Consultee Comments for Planning Application 23/03271/VAR

Application Number: 23/03271/VAR

Proposal: Variation of Condition 14 (approved plans - to retain as built ridge height to Plot A and repeat to Plot B and as built footprints to Plot A and B) of planning permission 23/00994/VAR (Erection of 2 dwellings with integral garages and shared access following the demolition of existing dwelling and garage to allow for the inclusion of 2metre high fence on inside of hedge to western boundary erected, additional planting to northern boundary to include new hawthorne hedge either side of access driveway, amendment to rear elevations to include removal of sidelights to patio door and doors changed to 2100mm wide sliding type)

Name: . Yorkshire Water Services Ltd Developer Services

DRG NO: RS/001/04

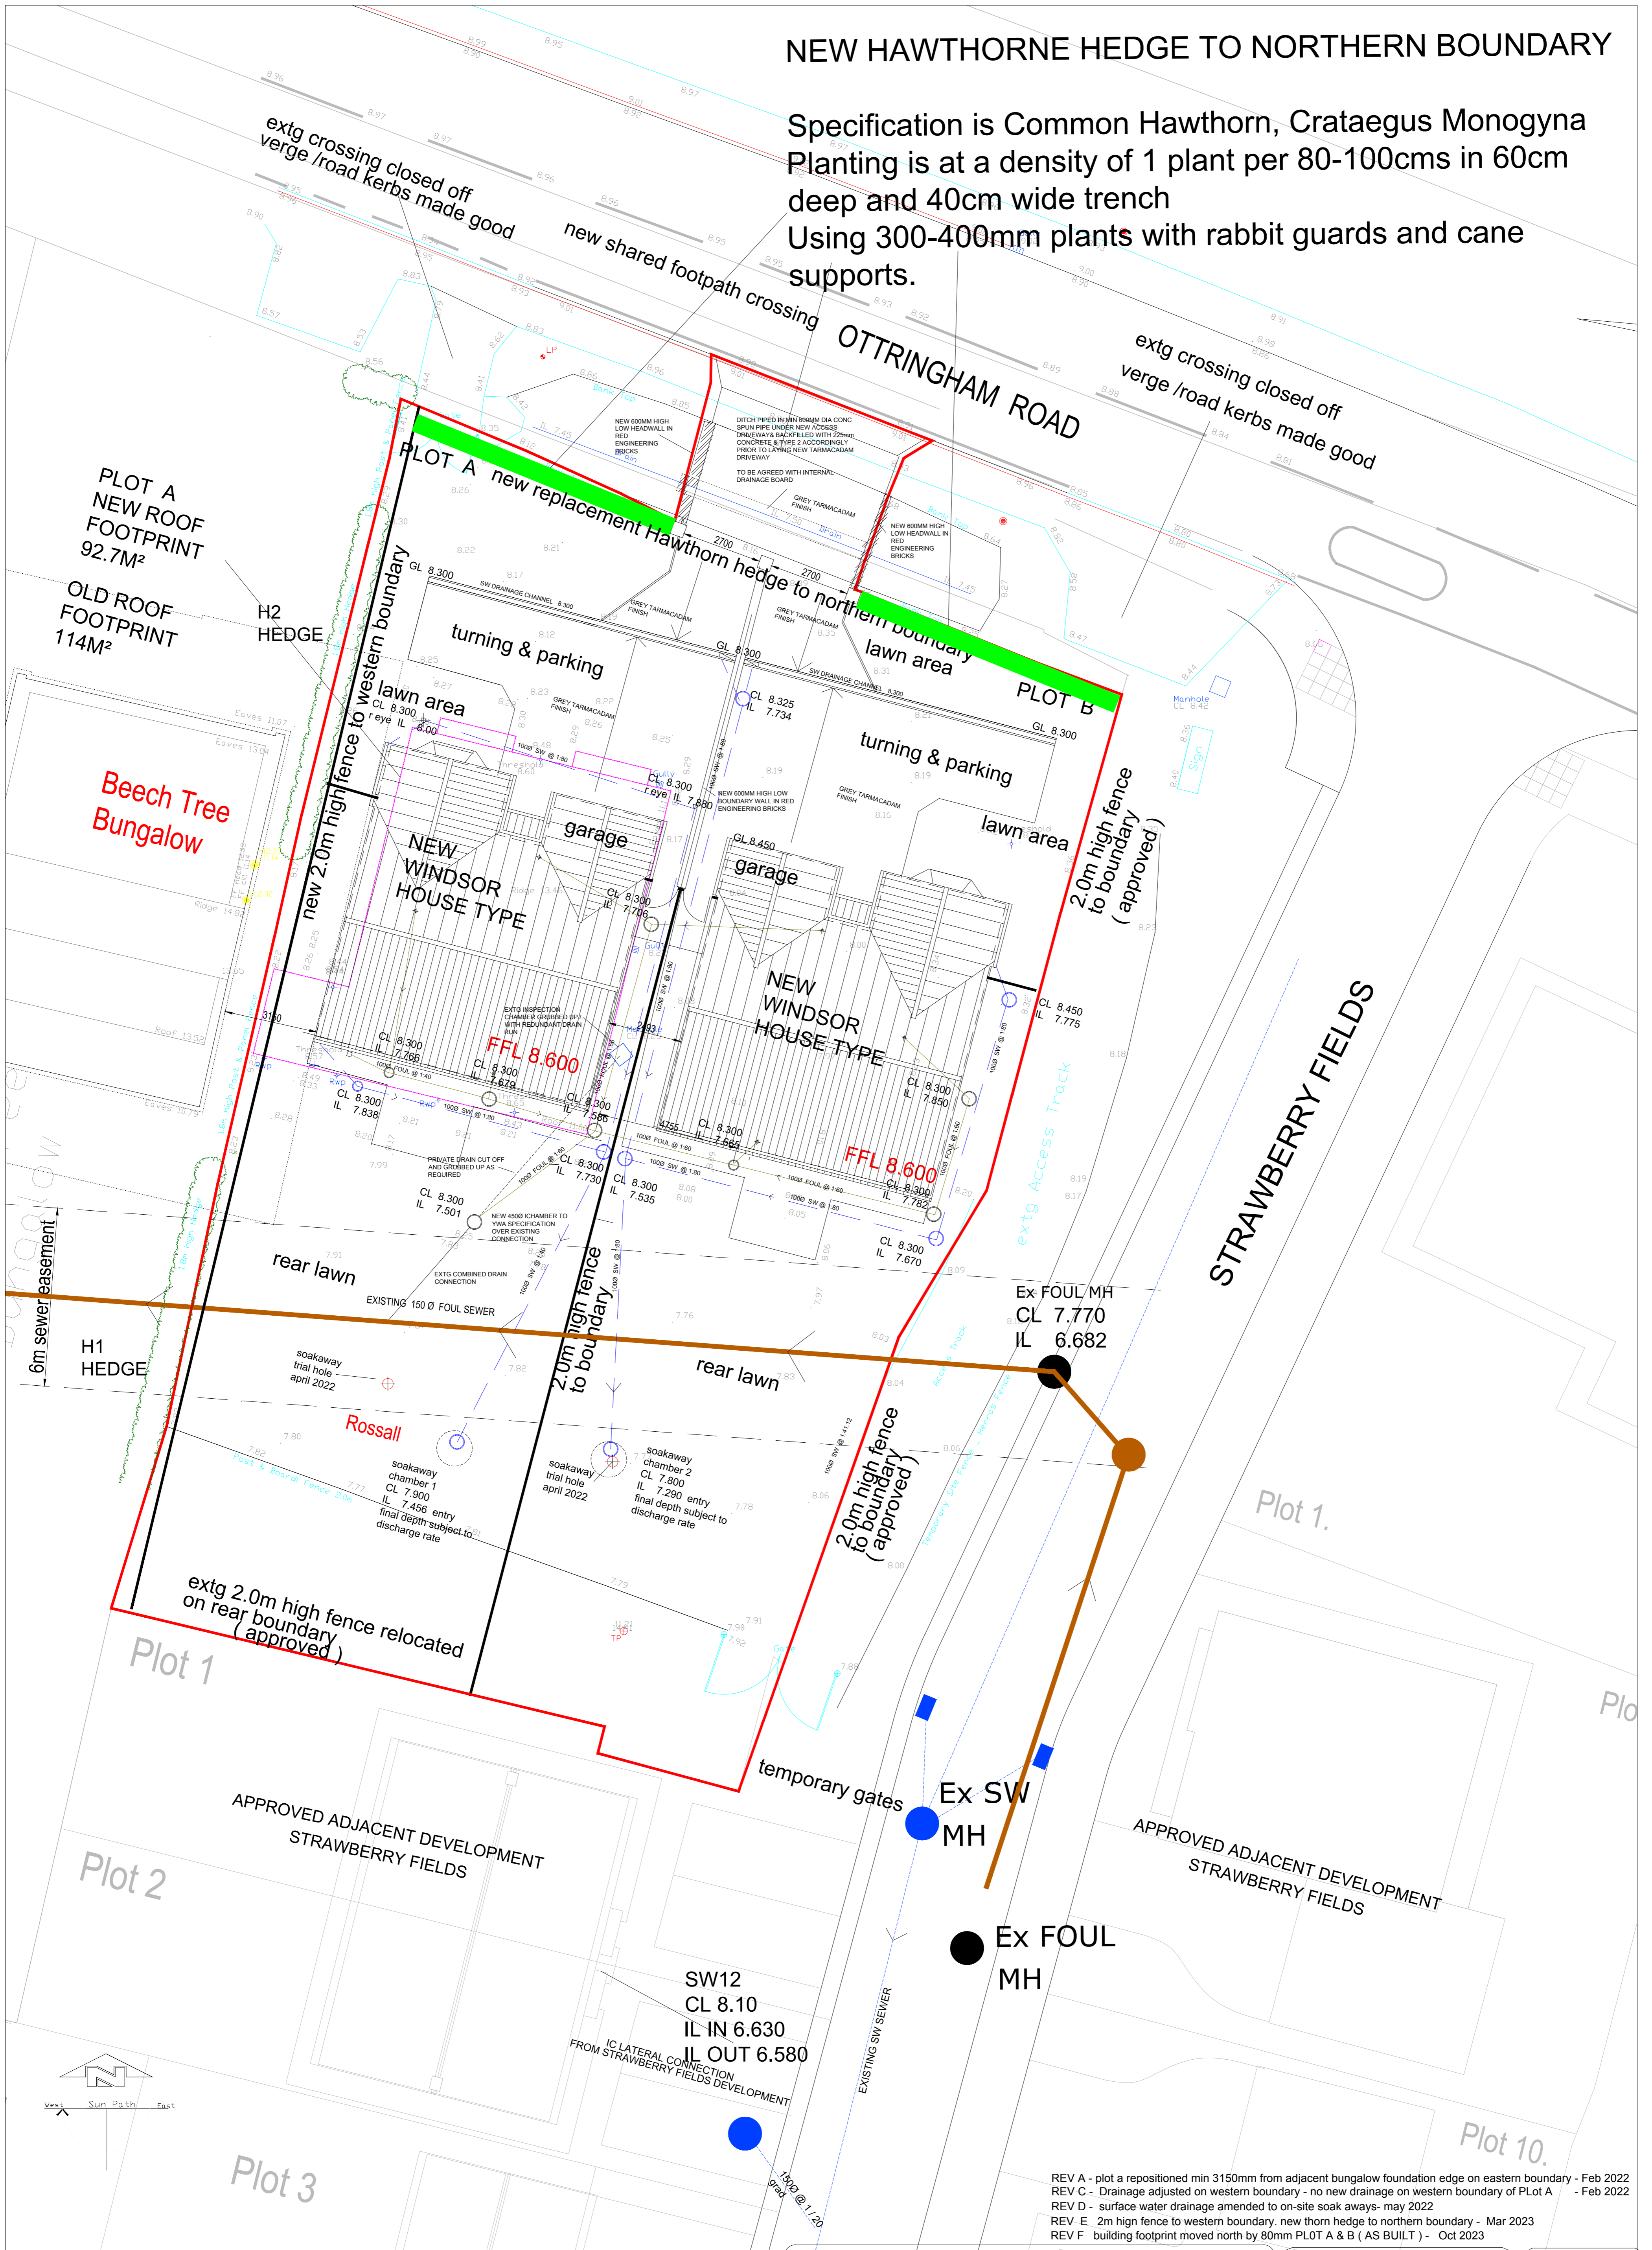
1.) Yorkshire Water has no objection in principle to:

- a.) The proposed building stand-off from public sewer centre-line (of three metres)
- b.) The proposed separate systems of drainage on site
- c.) The proposed amount of domestic foul water to be discharged to the public foul water sewer
- d.) The proposed amount of curtilage surface water to be discharged to soakaway
- e.) The proposed point(s) of discharge of foul water to public sewer

submitted on drawing 'Proposed Drainage Plan' RS/001/04 (revision F) dated Oct 2023 that has been prepared by C.C.F.D Ltd
